Contact Julia Puton
Tel 01992 556441
Email FRMConsultations@hertfordshire.gov.uk

Date 15 April 2019

RE: 6/2019/0085/MAJ – Chancellors School, Pine Grove, Brookmans Park, Hatfield, AL9 7BN

We understand this application seeks full planning permission for a major development, and we have assessed the Flood Risk Assessment and Drainage Strategy prepared by Ingent Consulting Engineers, dated March 2019 and the additional information submitted to support to this application. However, the information provided to date does not provide a suitable basis for an assessment to be made of the flood risks arising from the proposed development.

Drawing Title
 SURFACE WATER DRAINAGE STRATEGY
 EXISTING AND PROPOSED
 IMPERMEABLE AREAS

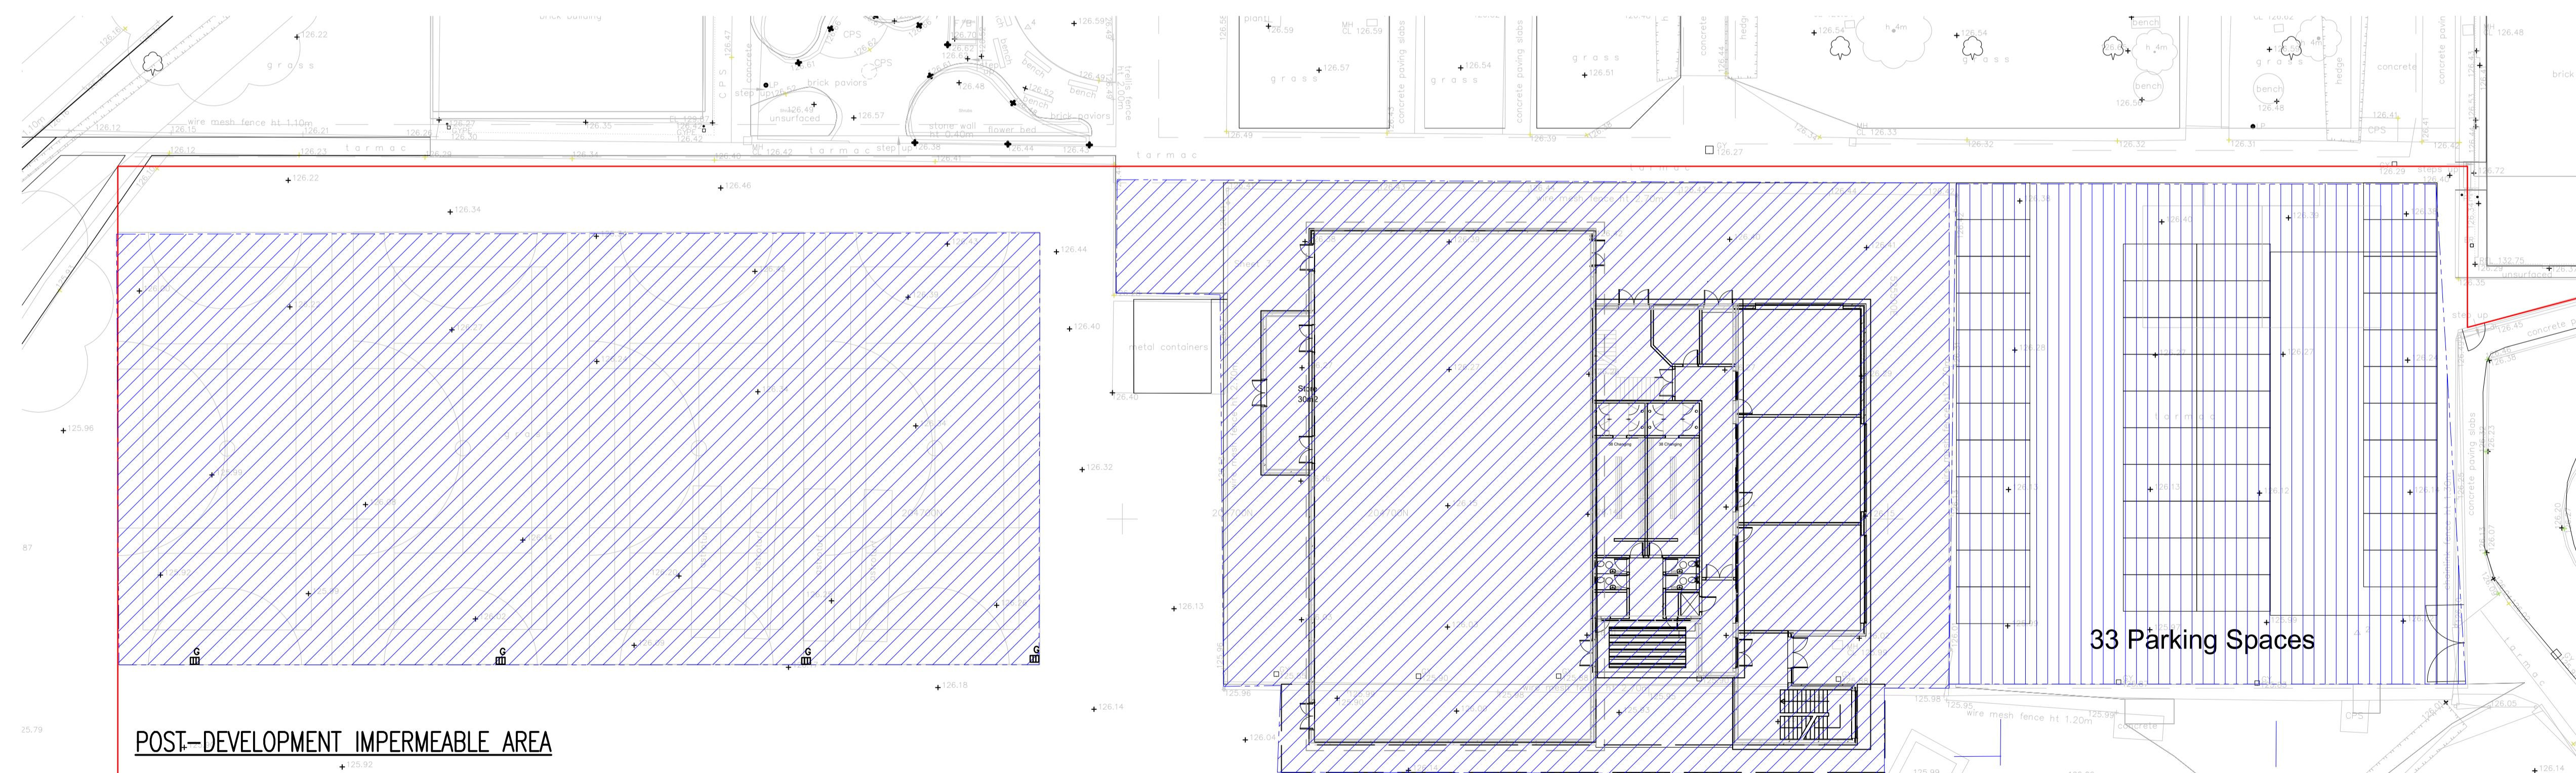
However, we note that the proposed parking spaces are not positively drained, as there is no existing drainage. We understand that an additional treatment stage will be proposed to manage any possible contamination arising from the proposed parking area.

We would advise the applicant that the proposed parking area should be entirely included in the modelling.

We are happy to find that the applicant intends to limit all the run-off from the site to 5 l/s. We would advise that this discharge rate should be applied to the entire development site.

Therefore, we would advise the applicant that the proposed modelling should be updated to include the above.

Based on our comments included in point 1, we would advise the applicant that the drainage layout should be updated to include all the charges.

Moreover, we would advise that the proposed storage volumes should be indicated on the drainage scheme layout.
